Recommendation Report for Planning Permission for Works or Extension to a Dwelling

REF NO: P/118/20/HH

LOCATION: 35 Sea Lane
Pagham
PO21 4UW

PROPOSAL: Single storey side infill extension and first floor front extension to remove existing balcony with front bay window.

sheet 1 of 3

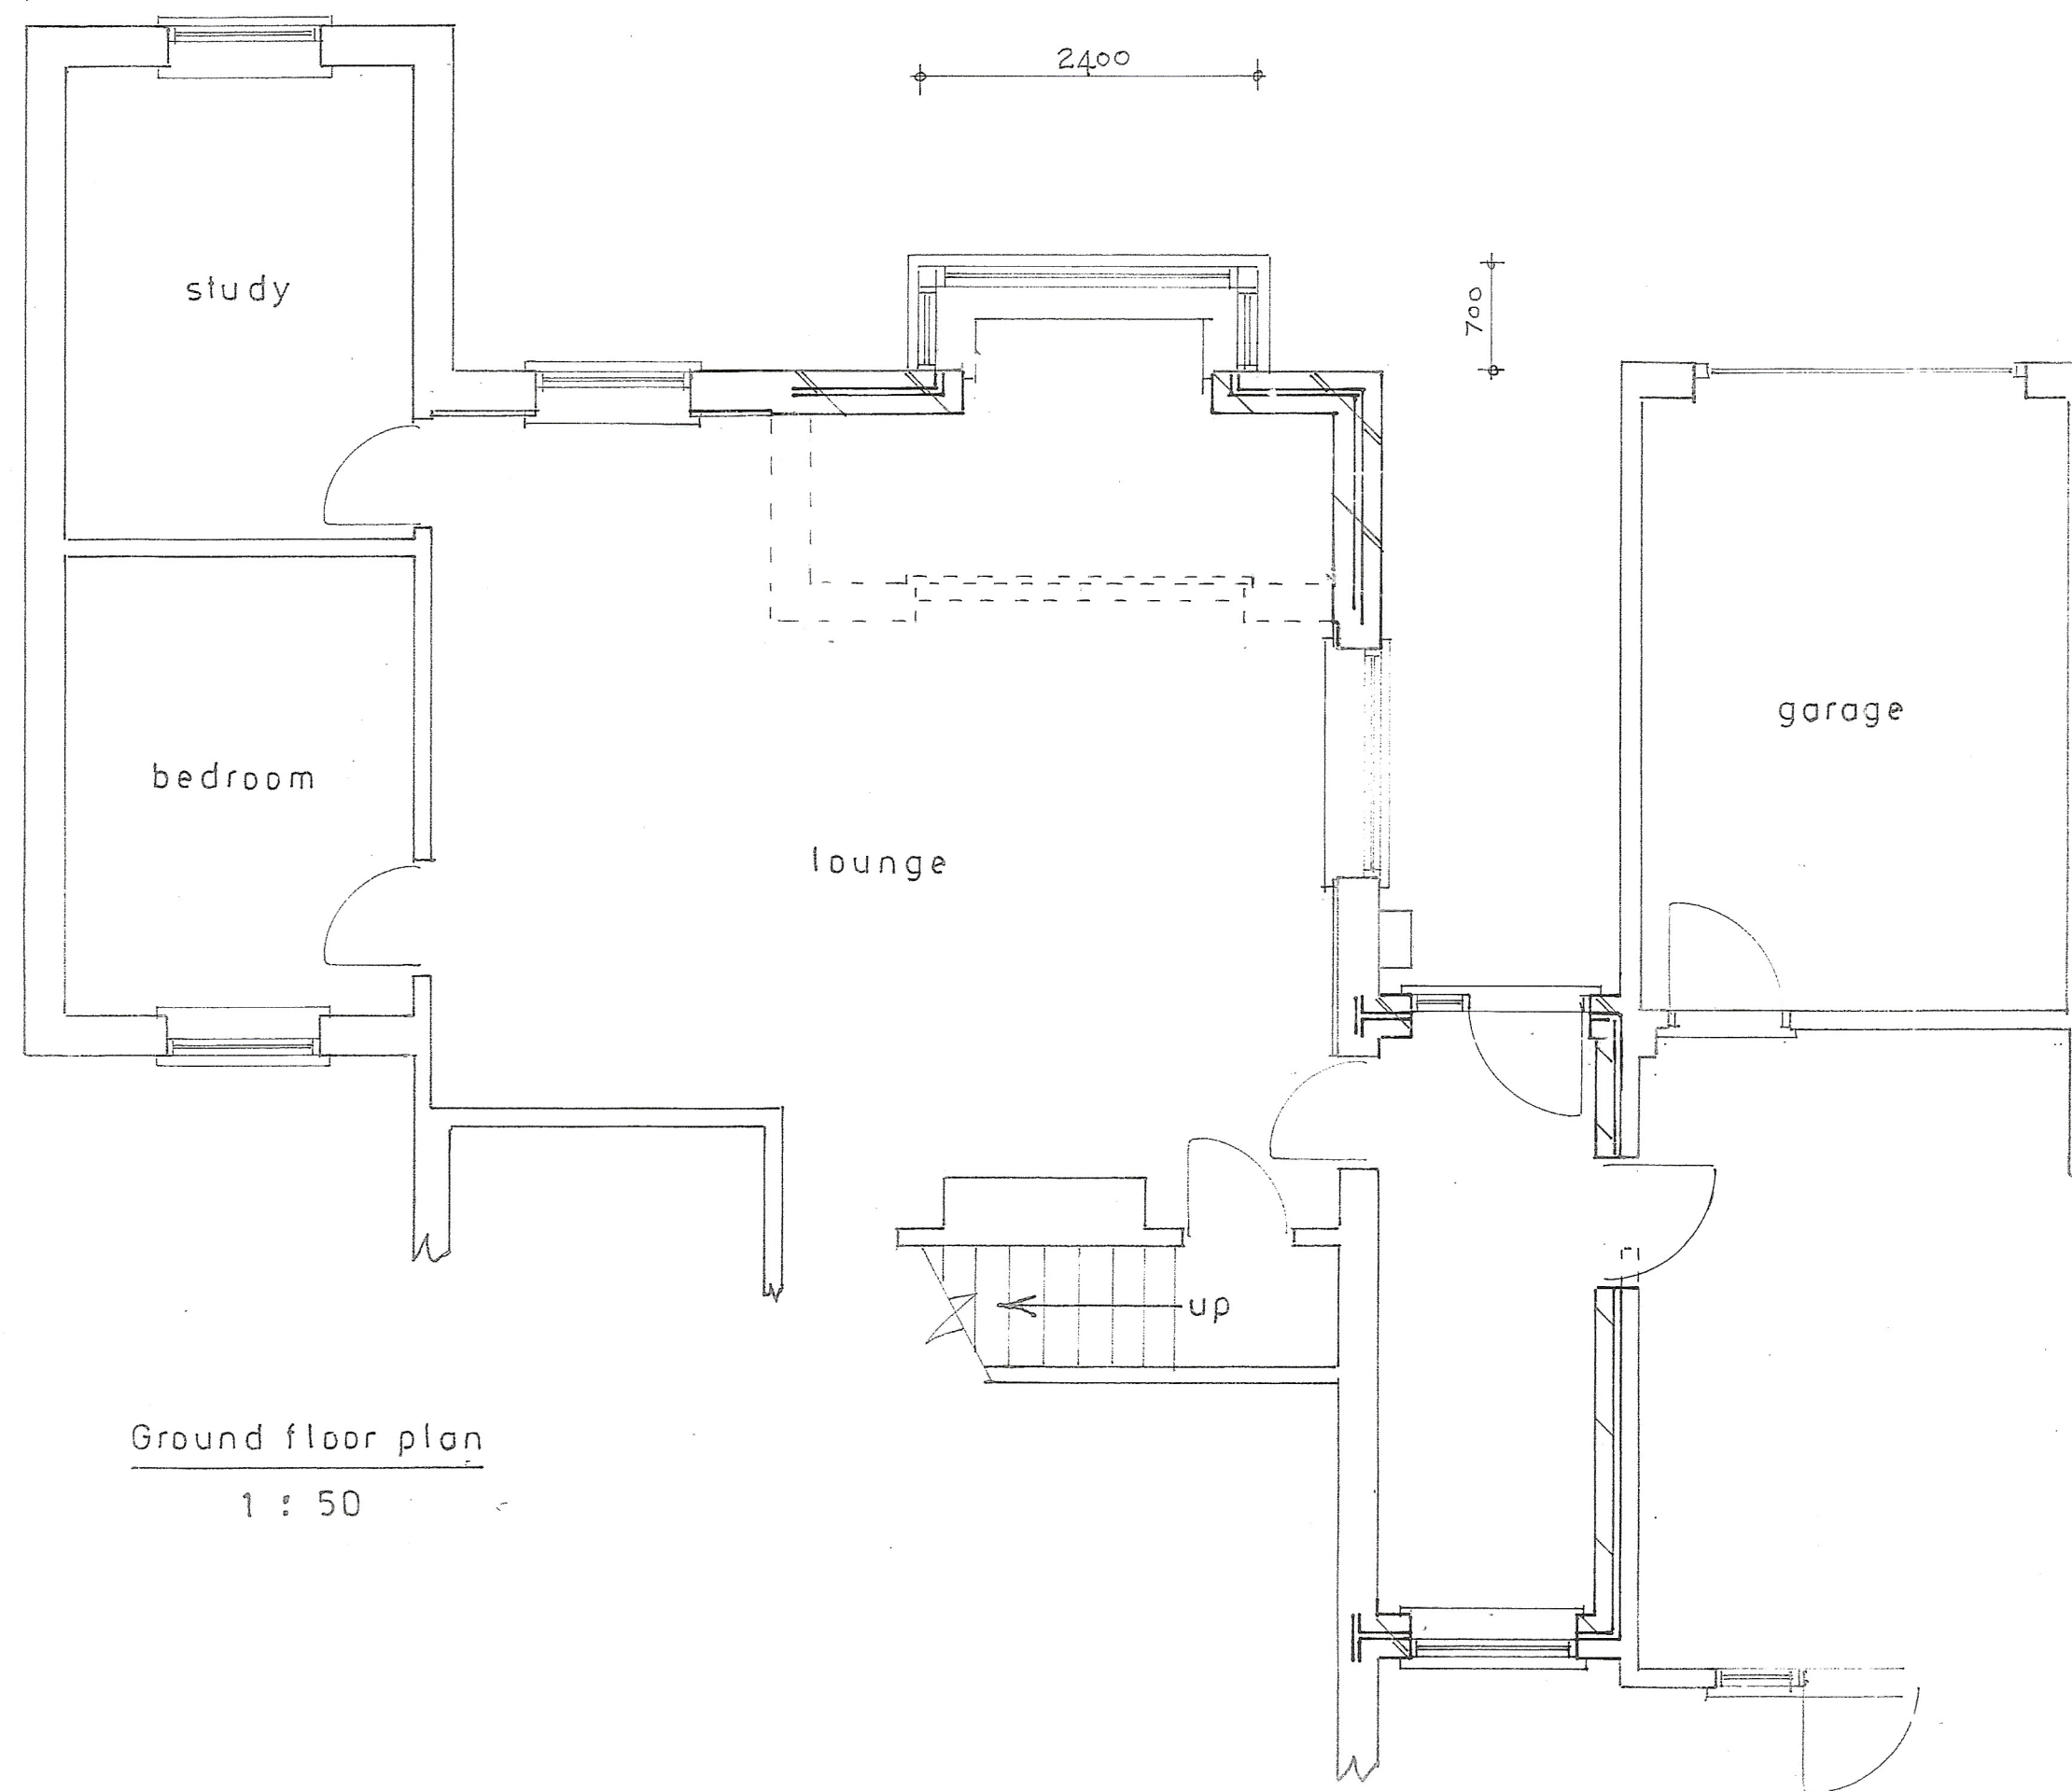
A side/infill extension is also proposed. This is situated to the western side of the property, located between the dwelling and detached garage. This meet with the rear of the dwelling. It will have a flat roof and due to its siting next to 2 pitched roof structures it will not be visible from the neighbouring properties is not considered to give rise to harm.

sheet 2 of 3

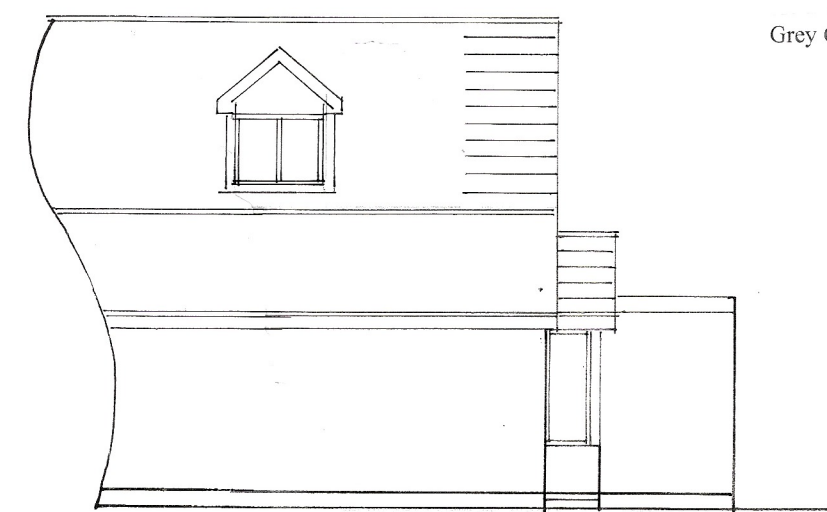
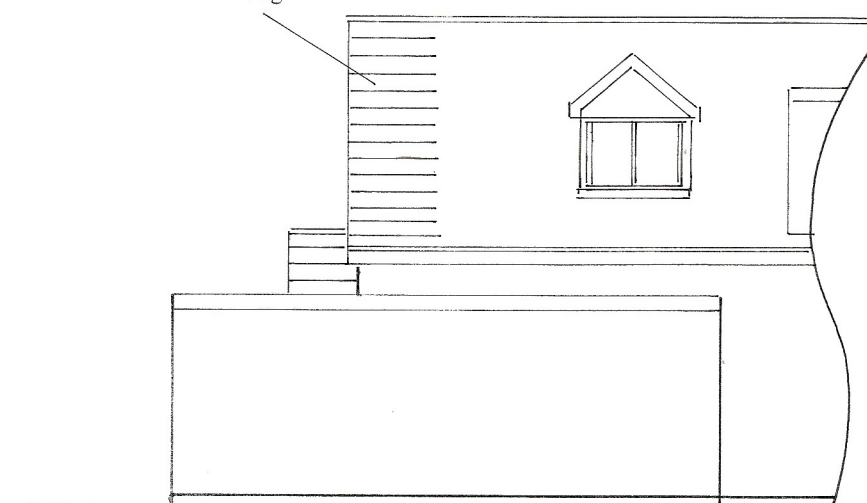
The dwelling currently has balcony to the front with a canopy area beneath forming a covered porch. The proposal will construct a first floor extension which essentially infills the existing balcony. There will also be a small addition to the ground floor forming a bay window of approximately 0.8m depth. This has a pitched roof although retains around 7m to the boundaries.

Cladding is proposed to the external front elevation of the dwelling a C07 Cream White. There are examples of cladding within the area and as such the use of the material is considered acceptable.

The proposal will infill the front balcony which serves a bedroom. This will have depth of 1.2m with the ridge height extending in line also.

There is a dormer window to the neighbouring property at the eastern side however due to the modest depth of the extension at first floor level it is not considered to give rise to an overbearing impact. The removal of the balcony is also considered to reduce overlooking available upon the dormer windows.
